Arun District Council
Arun Civic Centre
Maltravers Road
Littlehampton
West Sussex BN17 5LF
Planning & Building Control General Enquiries
Tel: (01903) 737756 Fax: (01903) 730442
Dx: 57406 Littlehampton
Minicom: 01903 732765
e-mail: planning@arun.gov.uk
website: www.arun.gov.uk/planning

Application No: A/193/20/PL
Site Address: Ham Manor Cottage Ham Manor Way Angmering BN16 4JQ
Description of works: Erection of a 1 No. 3 bedroom chalet bungalow & detached garage. This site is in CiL Zone 3 and is CIL Liable as dwelling.

Thank you for your internet representation made on 14th February 2021 which has been recorded as an objection with the comments as follows:

Proposed Street Scene (Scale 1:200)

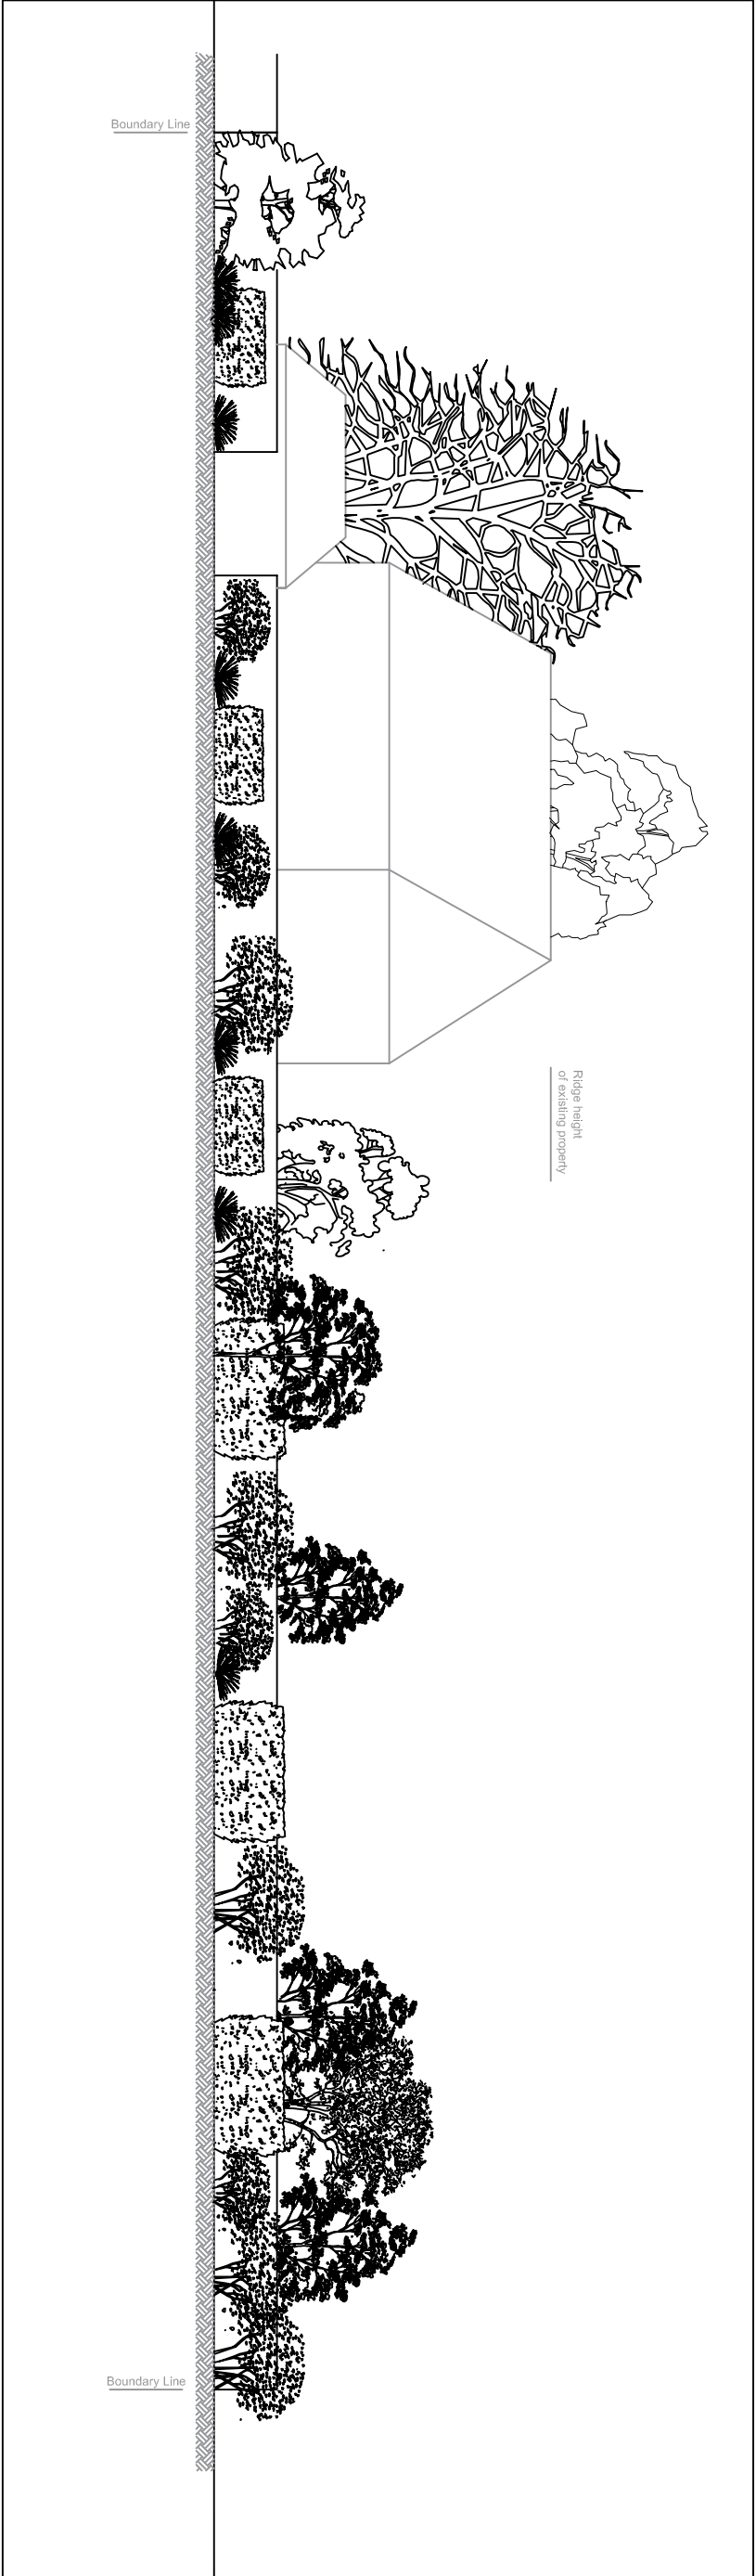
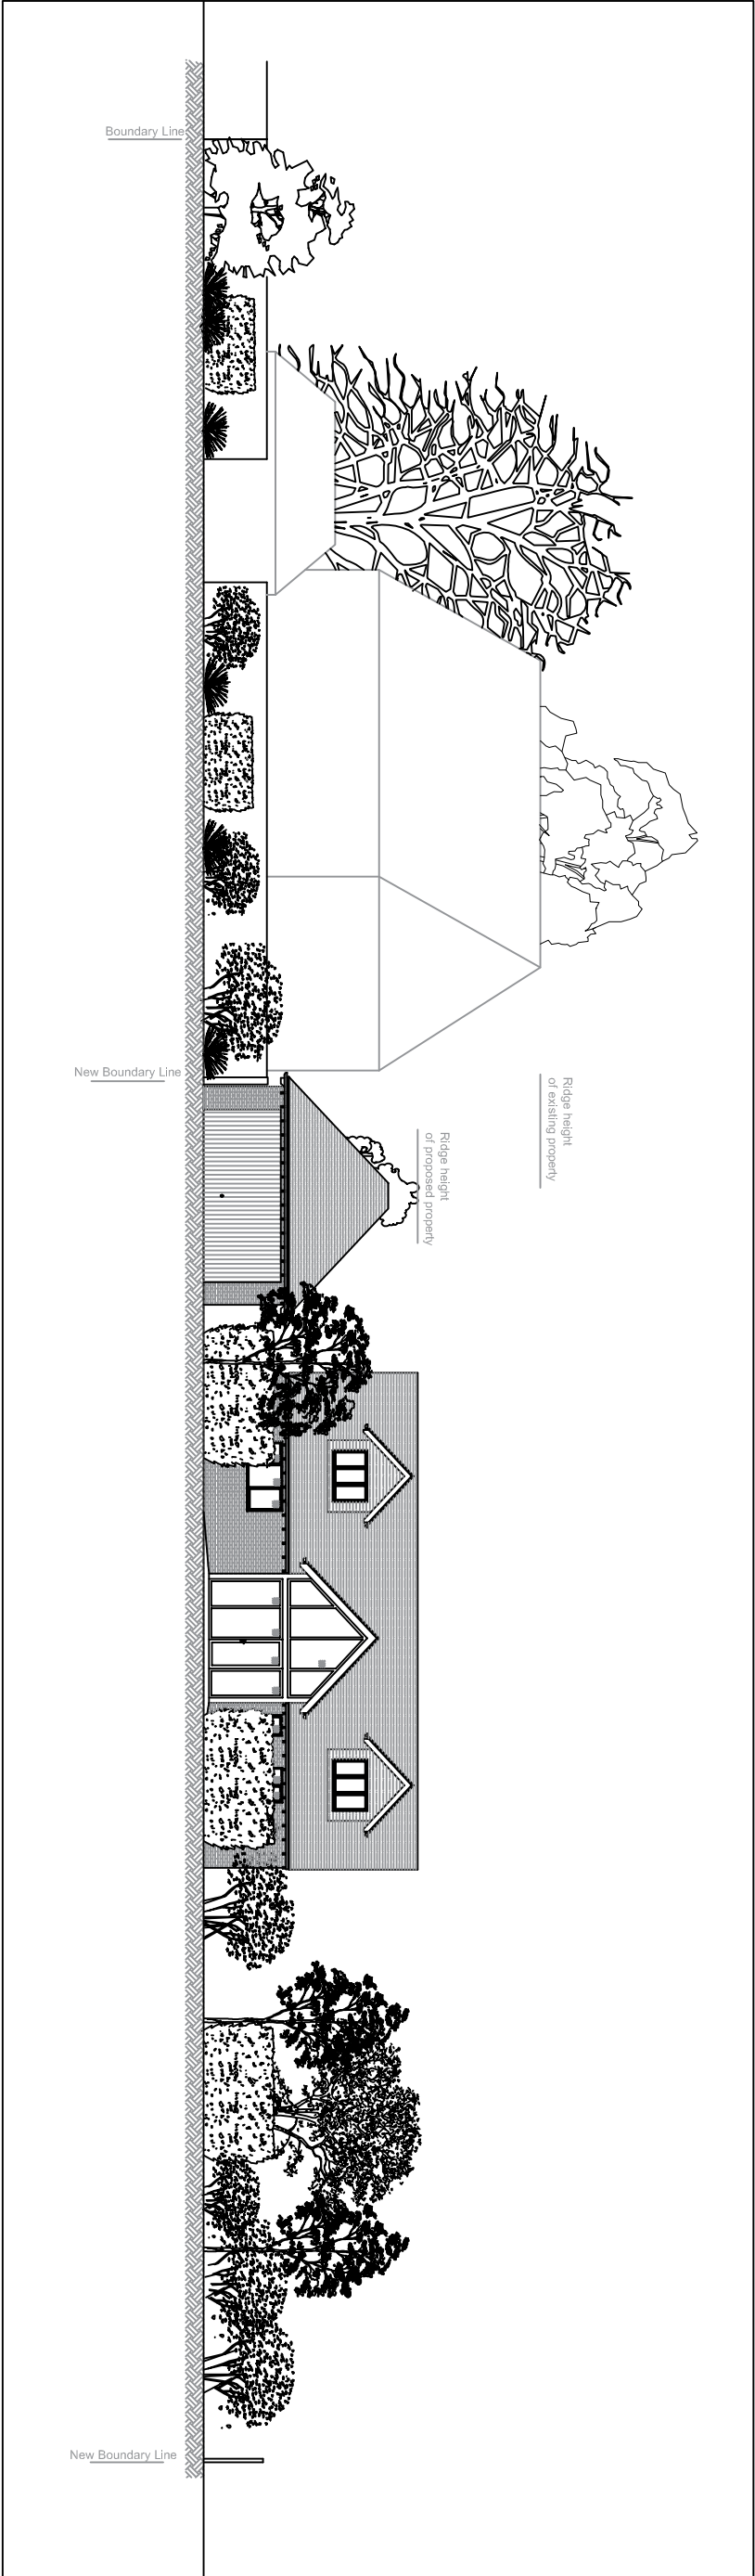
- * Due to the small plot size, the proposed property application has been submitted with boundary in front of the established building line of other properties in the road which will have a negative visual impact.
- * Applicants have already removed a number of large trees prior to submitting this application, and further established trees and vegetation will have to be removed for access to the property.
- * Conflicts with plans in the national policy framework and is contrary to elements of the local plan.
